DECISION DELEGATED TO HEAD OF PLANNING

Application No: H02-0365-25 **Applicant:** Ashwood Homes
Proposal: Details of external materials (Condition 3 of H02-0167-22)
Location: Land To The South East Of Harrington Drive Crowland Spalding
Terminal Date: 9th June 2025

This proposal seeks to discharge Condition 3 of planning approval H02-0167-22, relating to details in relation to the external materials.

DRAWING No: 132-MSL-20

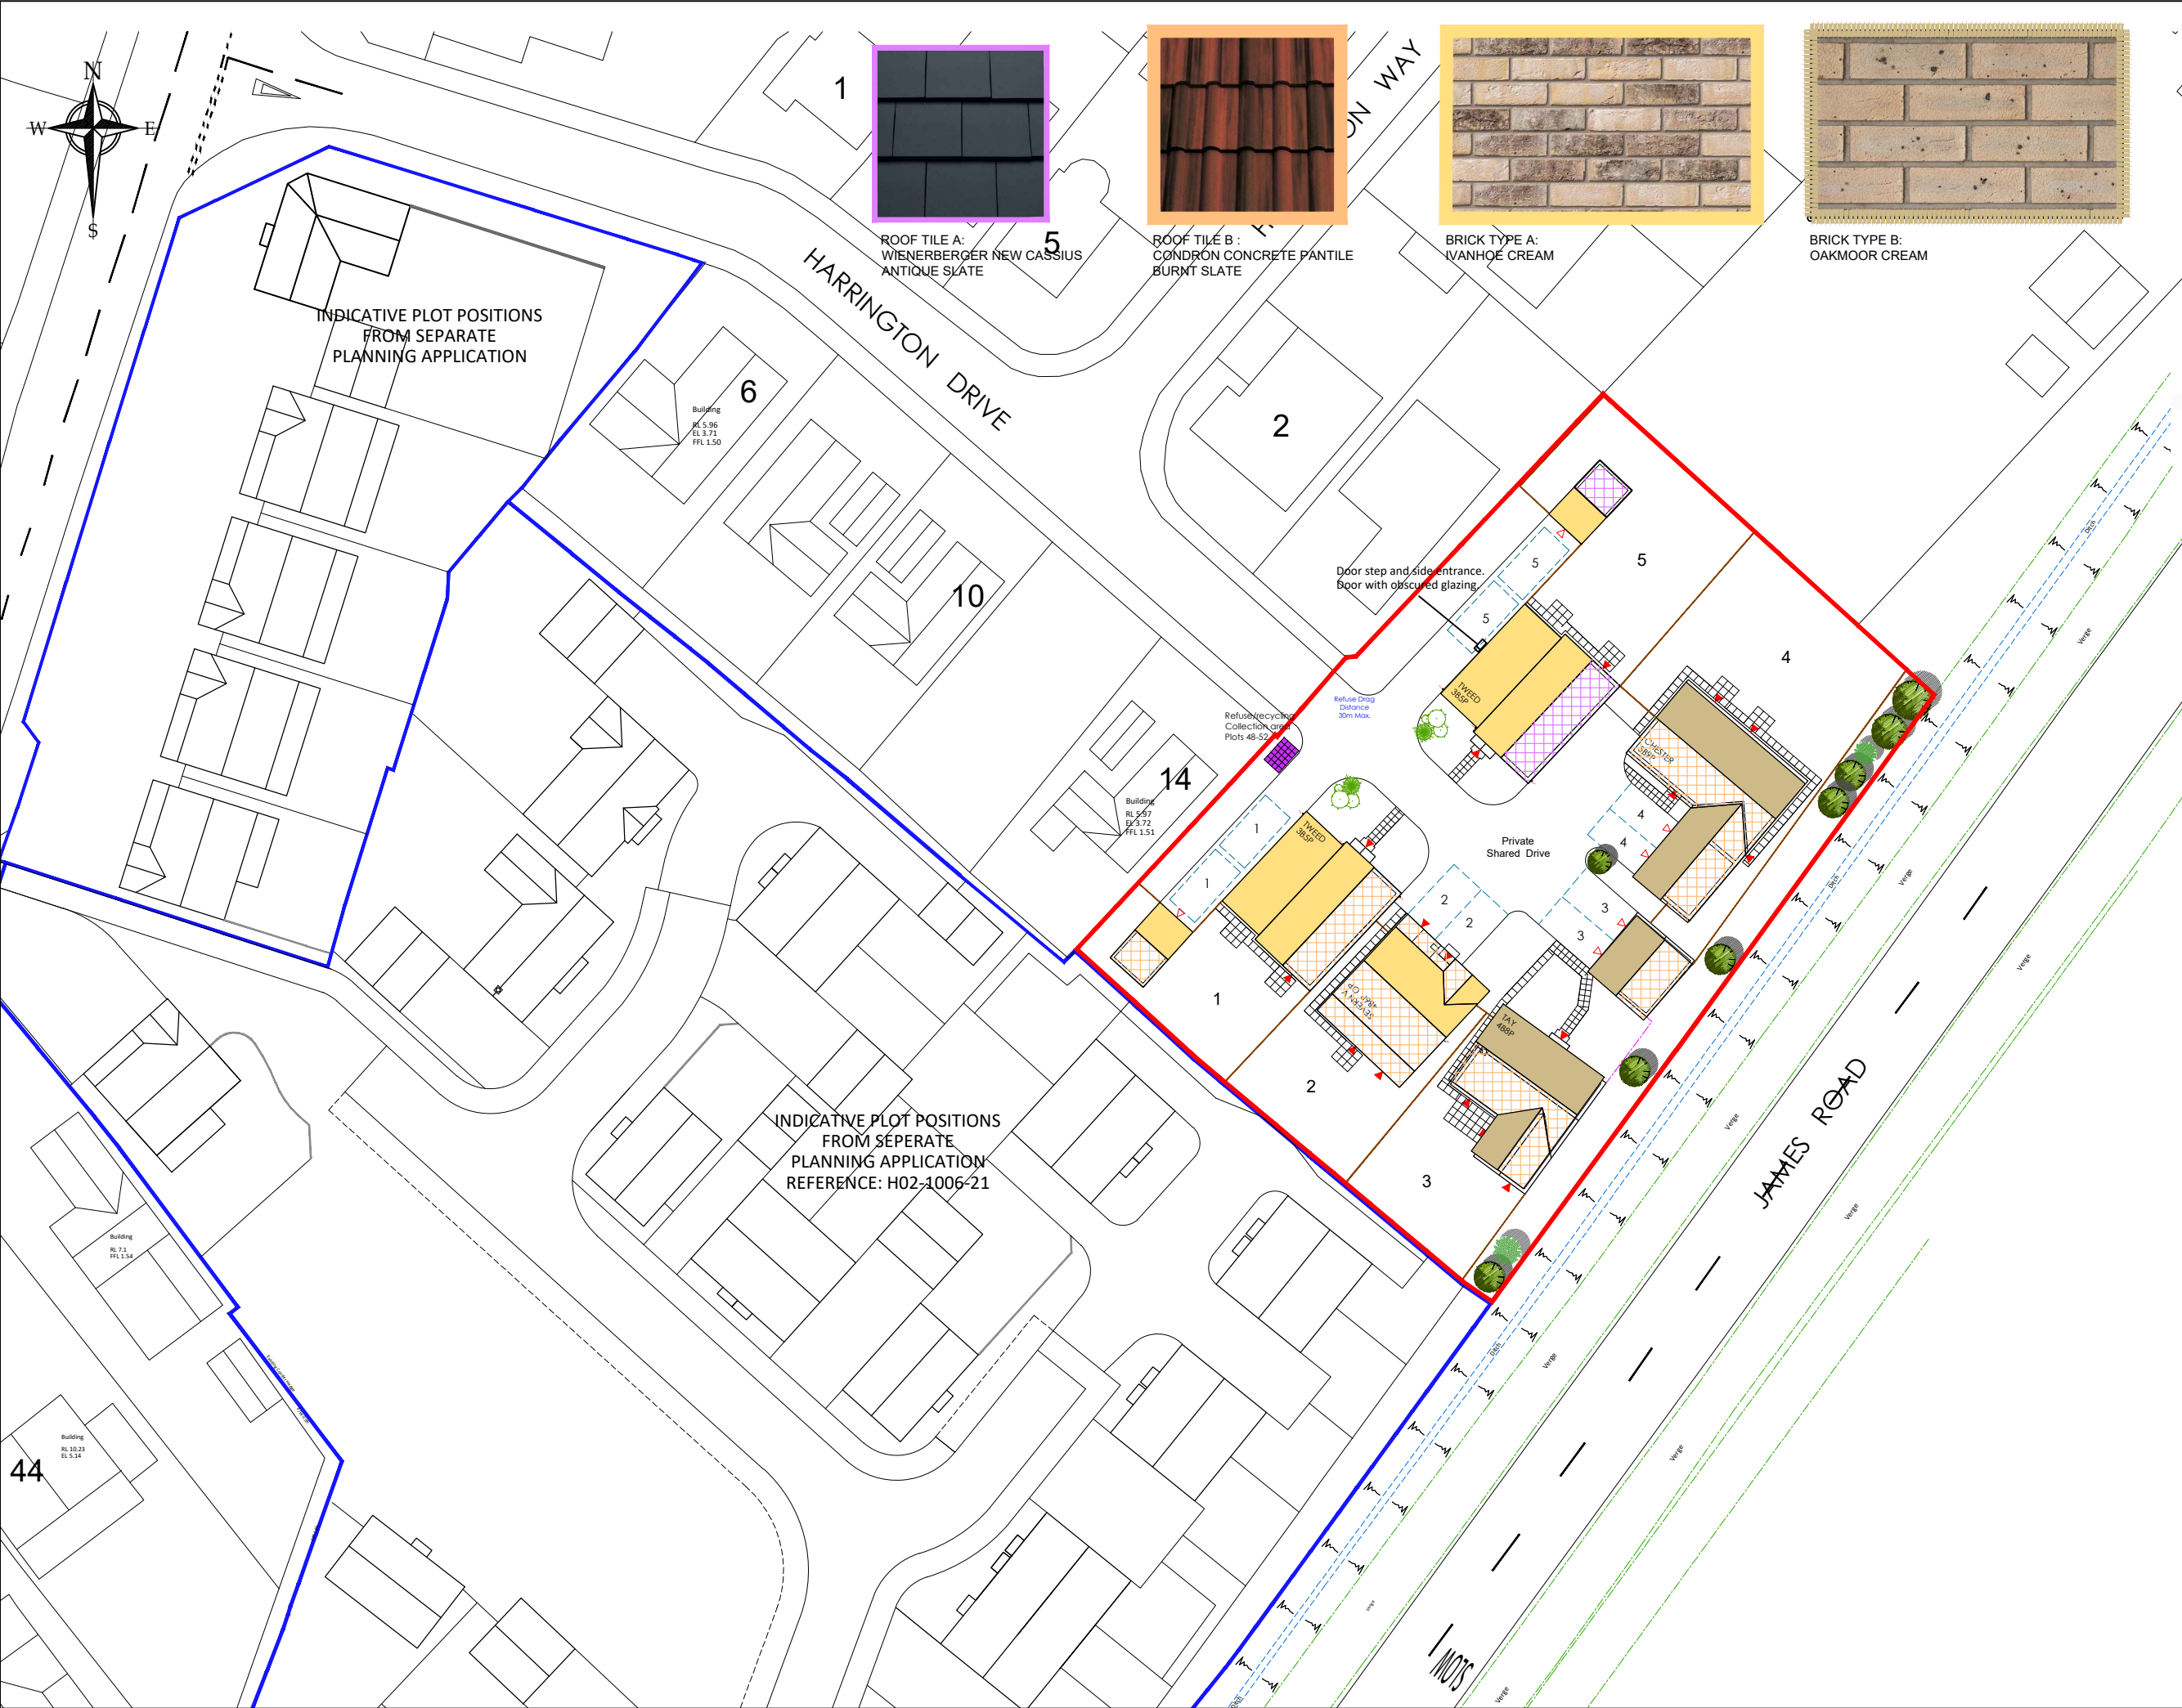
The applicant has provided a schedule of materials (drawing number 132-MSL-20) by Ashwood Homes. Plots 1, 2 & 5 are to be made up of 'Ivanhoe Cream' facing brick whilst 3 & 4 are to be finished in 'Oakmoor Cream'. All roofs are dressed in a concrete pantile in burnt slate apart from plot 5 which is to be Wienerberger New Cassius in Antique Slate. Rainwater goods, flue terminals and extract grills are all to be black.

This condition has previously been discharged, with this submission comprising a differing roof type for plot 5. Whilst differing, the alternative roof type is of a similar appearance, comprising a slate finish.

The submitted materials are considered to be in keeping with the character of the area and therefore are acceptable. The condition can be discharged.
